# **SUBMISSIONS REPORT**

SSDA-9838218

Griffith Base Hospital Redevelopment

25 August 2021

Figure 5. Proposal diagram showing development footprint and proposed remnant and planted NSW vegetation clearing and locations of hollow bearing trees.

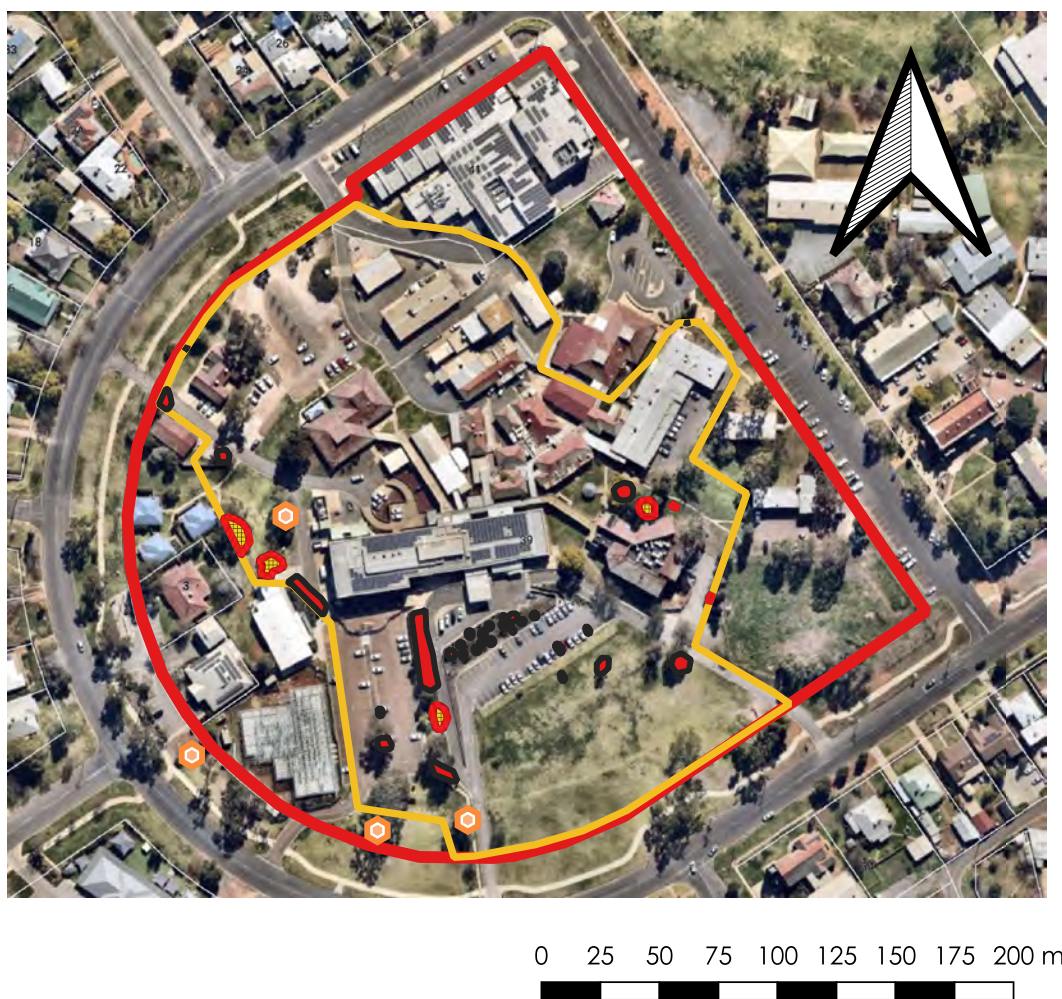
Issue	Referral Comment	Response to Submission	Reference to information
<b>Tree removal</b>	<p>Confirm the existing trees to be removed. Figure 5 of the BDAR shows the remnant vegetation within the development footprint to be removed and offset.</p> <p>However, the remnant vegetation at the southern boundary (Nooremar Avenue) is shown as being retained in the Landscape Report (Dwg. 0015) and the Arborist Report (Appendix 2).</p>	<p>Figure 5 on the amended BDAR has been updated to show the remnant vegetation along the southern boundary is to be retained.</p>	Appendix E
<b>Griffith City Council</b>			
Ambulance access on Warrambool Street	Concerns with traffic impacts associated with the ambulance access on Warrambool Street..	<p>Health Infrastructure held a meeting with Griffith City Council on 11 August to discuss solutions to possible traffic impacts associated with the ambulance access on Warrambool Street. The meeting minutes are provided at <b>Appendix H</b>.</p> <p>During the meeting, various pedestrian treatment measure were discussed. The Griffith City Council are supportive of the following pedestrian treatment measures proposed by Health Infrastructure. A copy of the meeting minutes noting the discussions and agreement are provided in Appendix H.</p>	Appendix H
